re: Application ref. LU/314/16/PL, Littlehampton Swimming & Sports Centre

We write in connection with the above planning approval and a non-material amendment to the submitted and approved documents. Following up on a previous email dated 11/03/19 an incorrect drawing was noted for the final car park lighting proposals; the drawing that shows the final lighting proposals is as listed below.

DRAWING
GA Site Plan

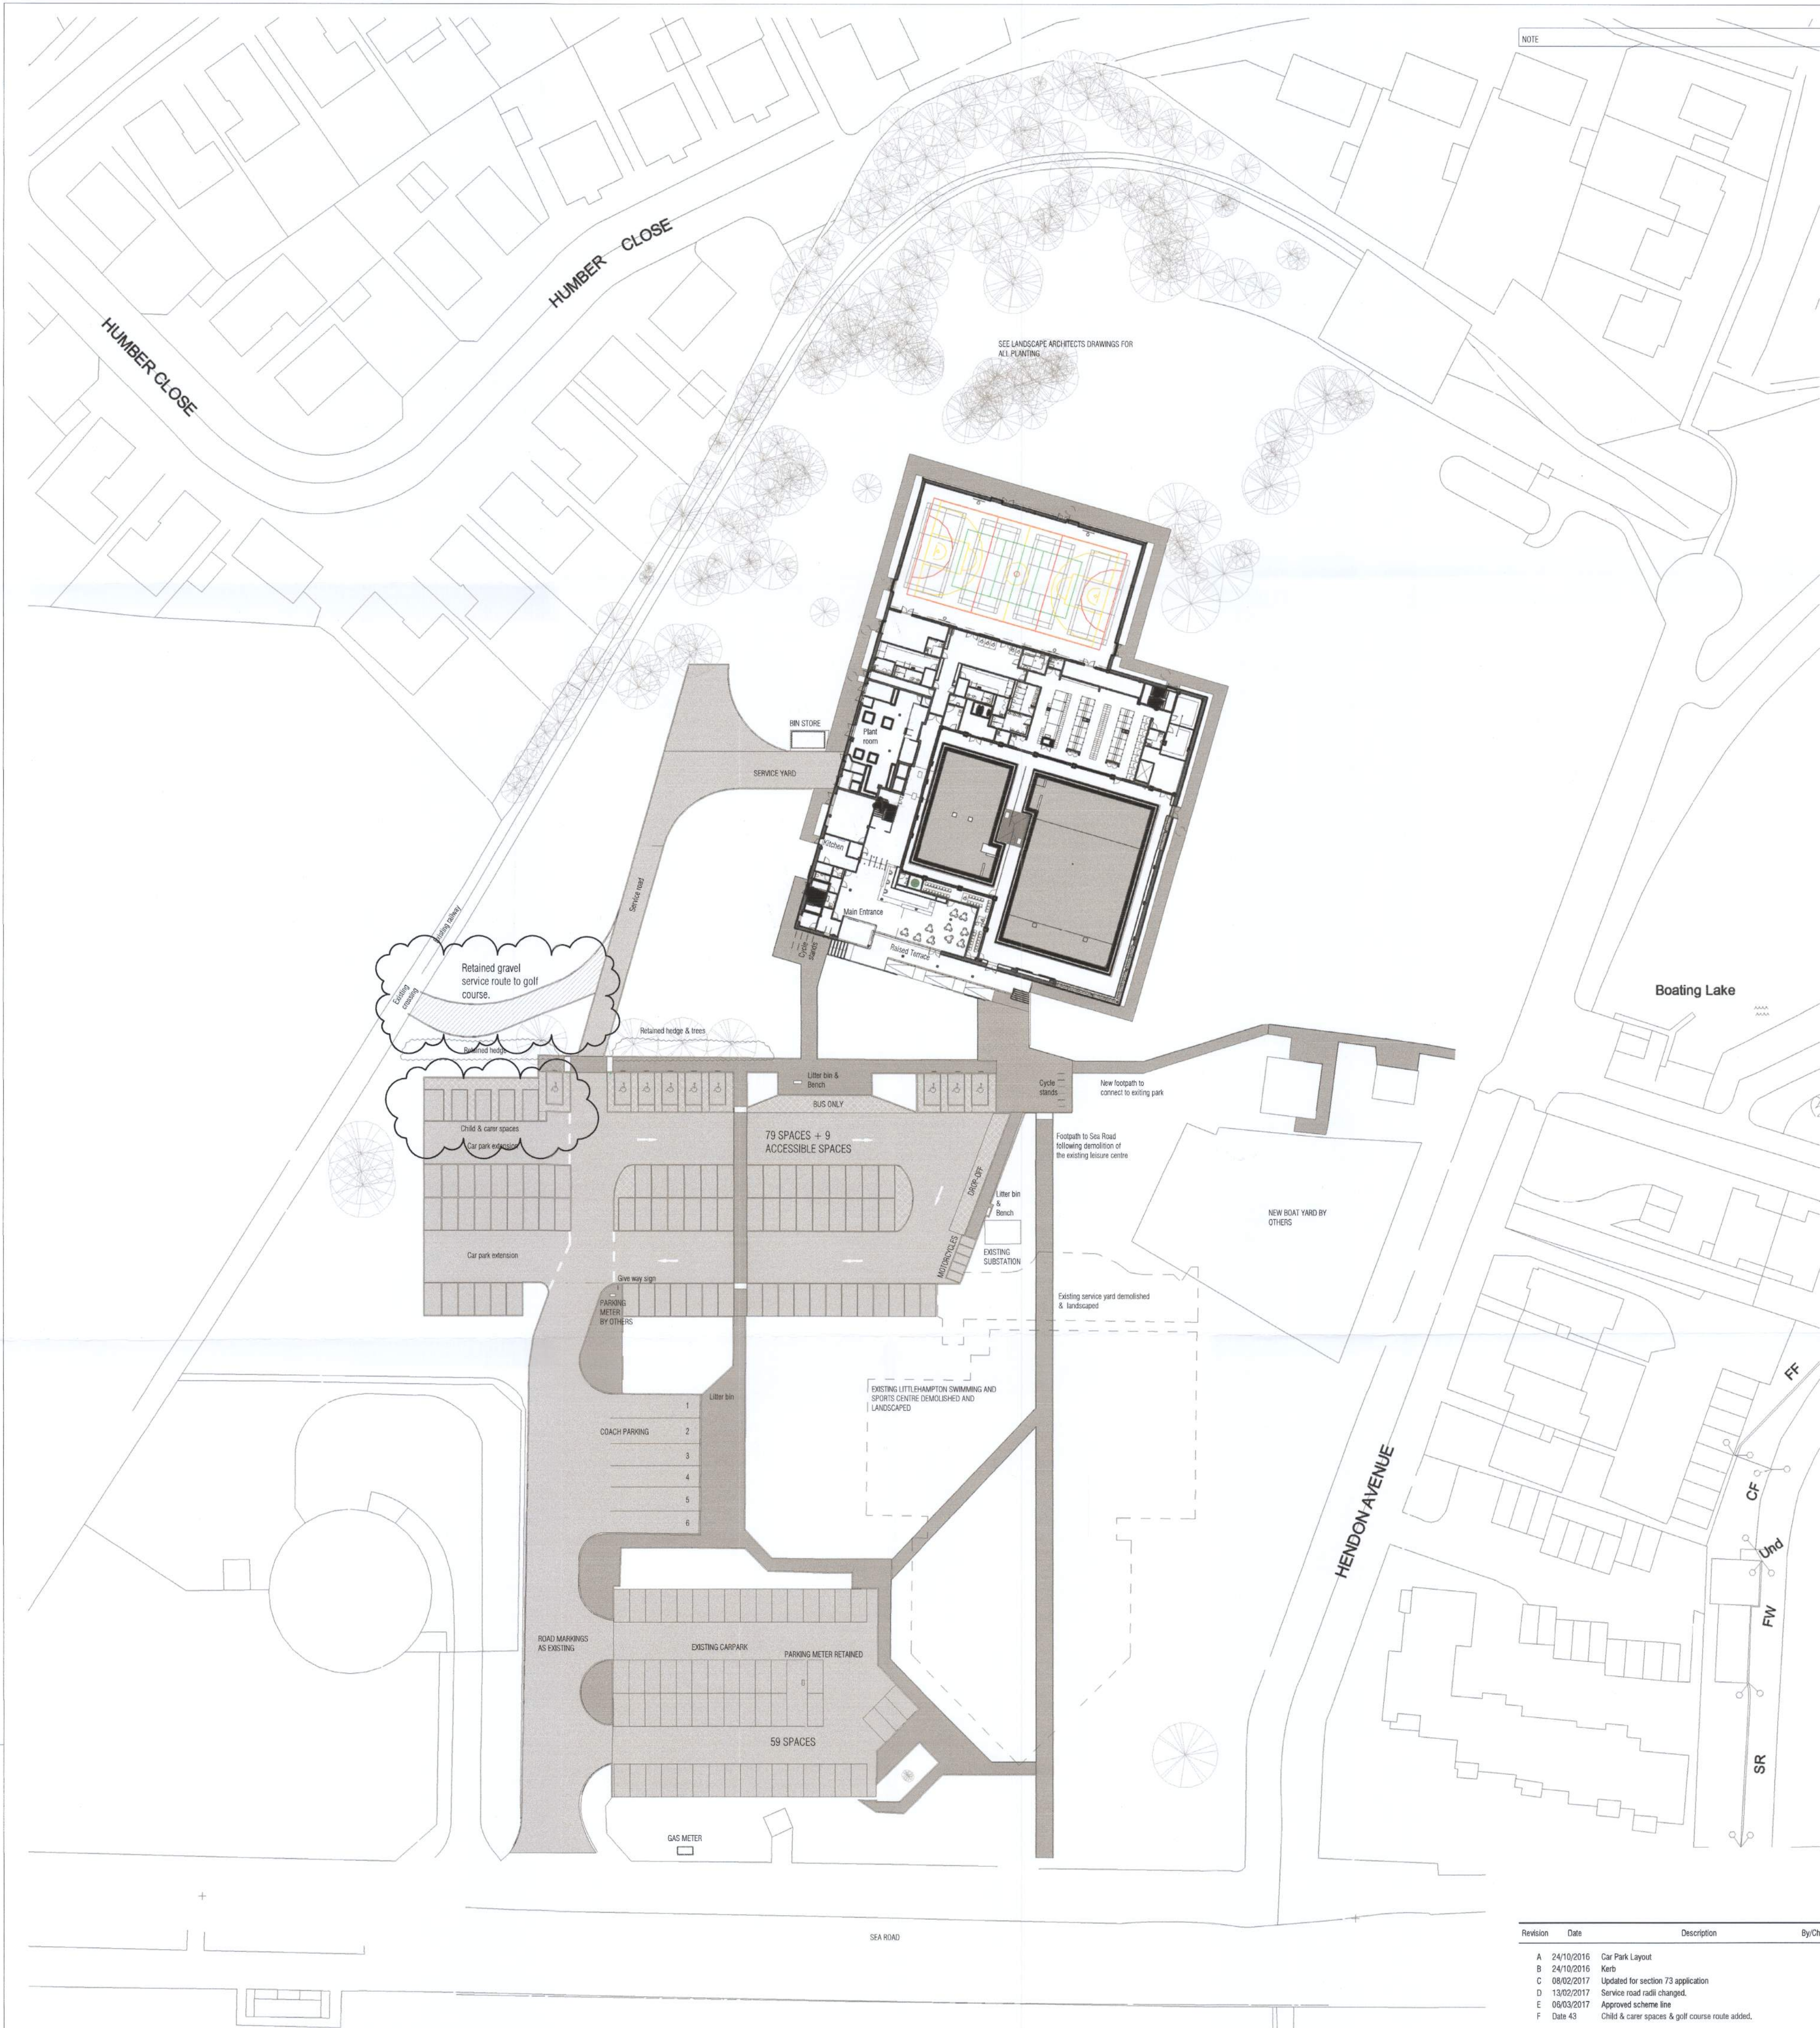
The proposed changes to be considered by the non-material amendment are to the approved car park layout to provide 5 dedicated parking spaces that offer access space to the sides and rear of the parked vehicle for carers with children; this will result in an overall reduction of 2 parking spaces.

Provision of a retained gravel vehicle service route from the leisure centre service road to the existing mini-rail line crossing for servicing the pitch and putt course. This is a formalisation of a previous casual route used by the Parks & Recreation Department, it will ensure safe vehicle access through the year and protect adjacent soft landscaped areas from vehicle damage.
